Date: 06/05/2024

Re: Framing Item
Location: Lot 26 Wellers Knoll (142 Van Winkle Street Lillington, NC)
JDS Project No.: RDU2405781
Date of Inspection: 06/05/24

S-3c
SECOND FLOOR
FRAMING PLAN

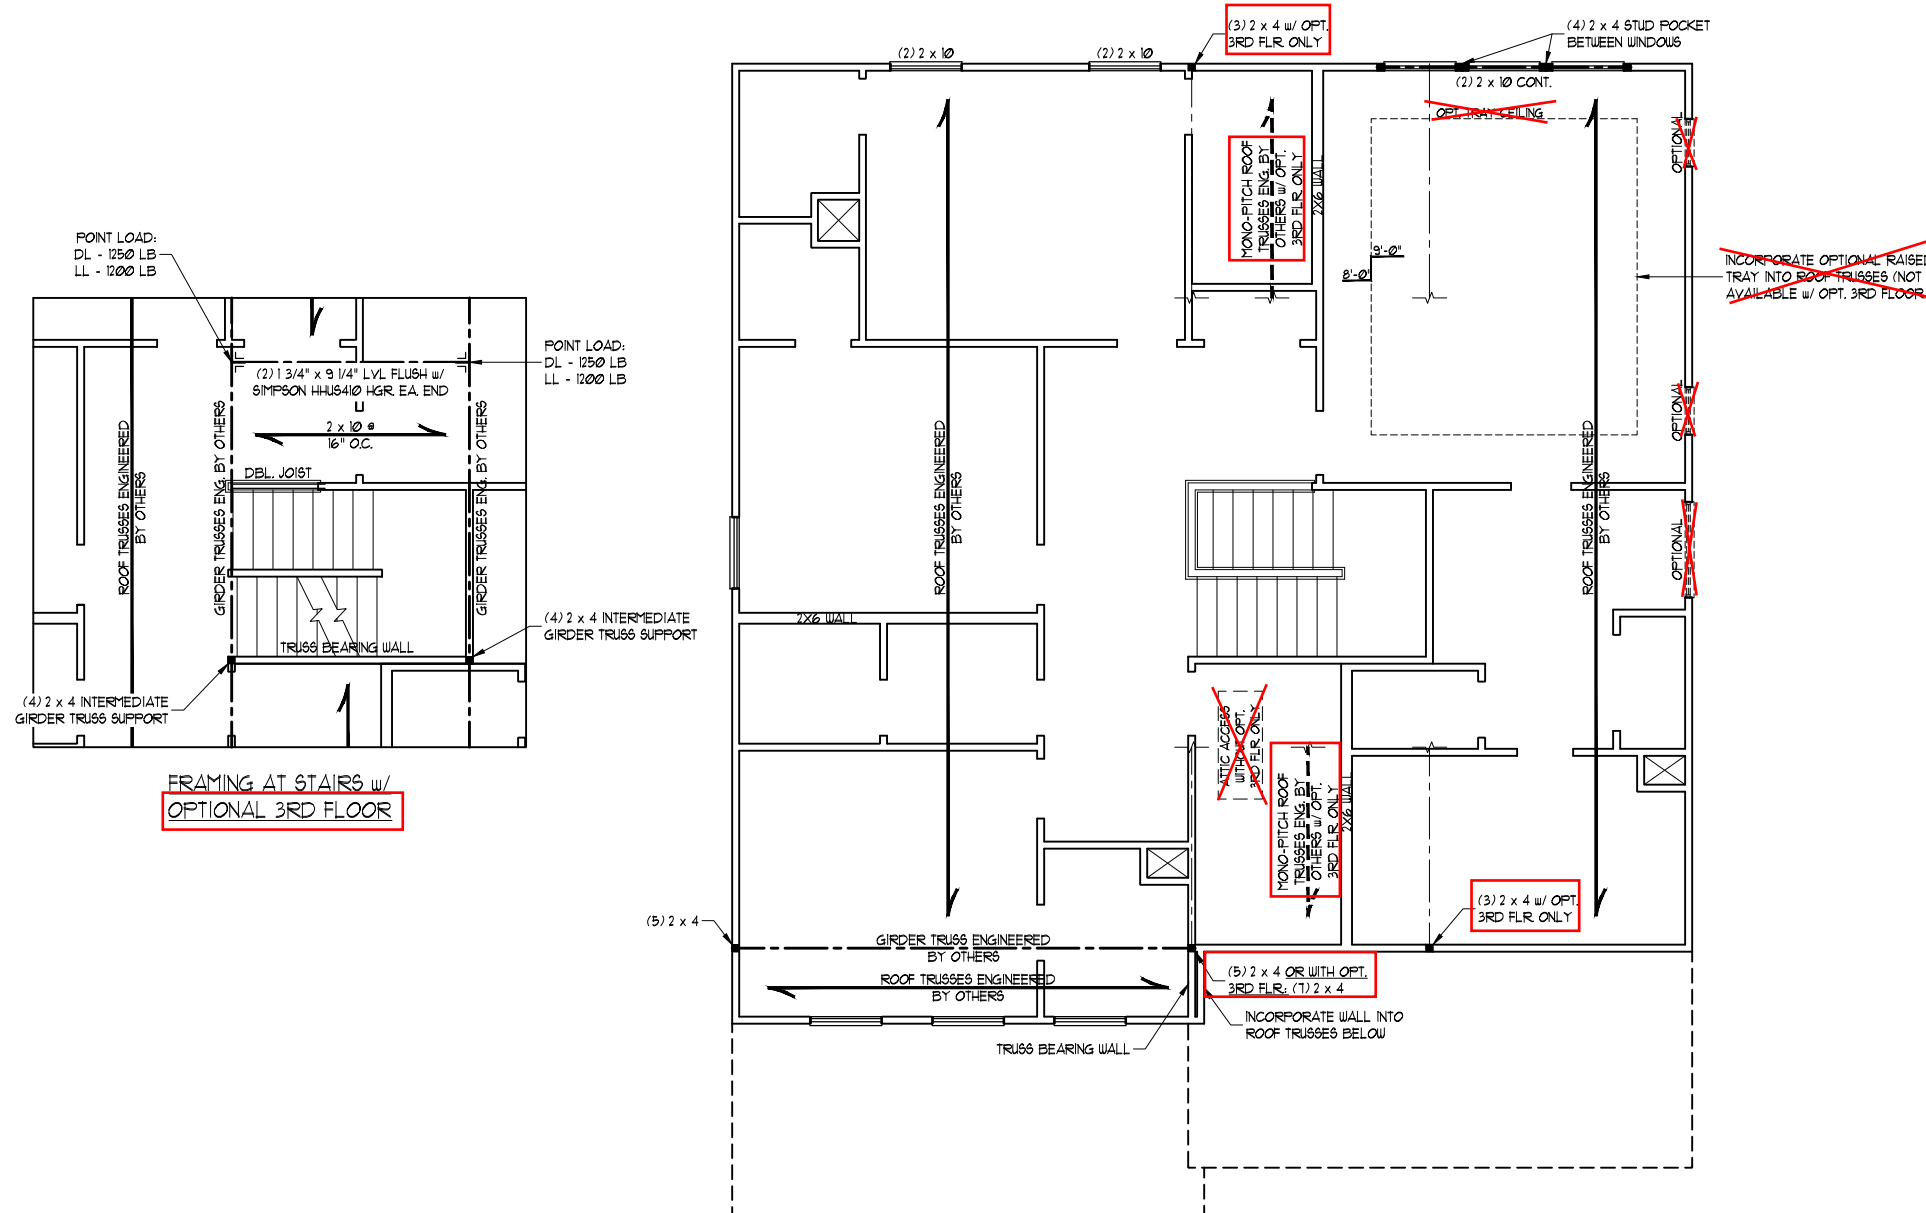
The client requests an evaluation of the 2nd floor 3rd 2x10 floor joist from the right exterior wall has an approximately 4-1/2" hole to allow plumbing penetration. The contractor has installed an approximately 4-1/2' long by full depth OSB scab on both sides.

Based on our on-site observations and review, the client shall add more nails in the OSB, (3) rows of 6d nails spaced at 4" o.c. Then install a 4-1/2' 2x4 scab on both sides, flush with the floor sheathing above, centered on the damage attached with (2) rows of 10d nails spaced at 4" o.c.
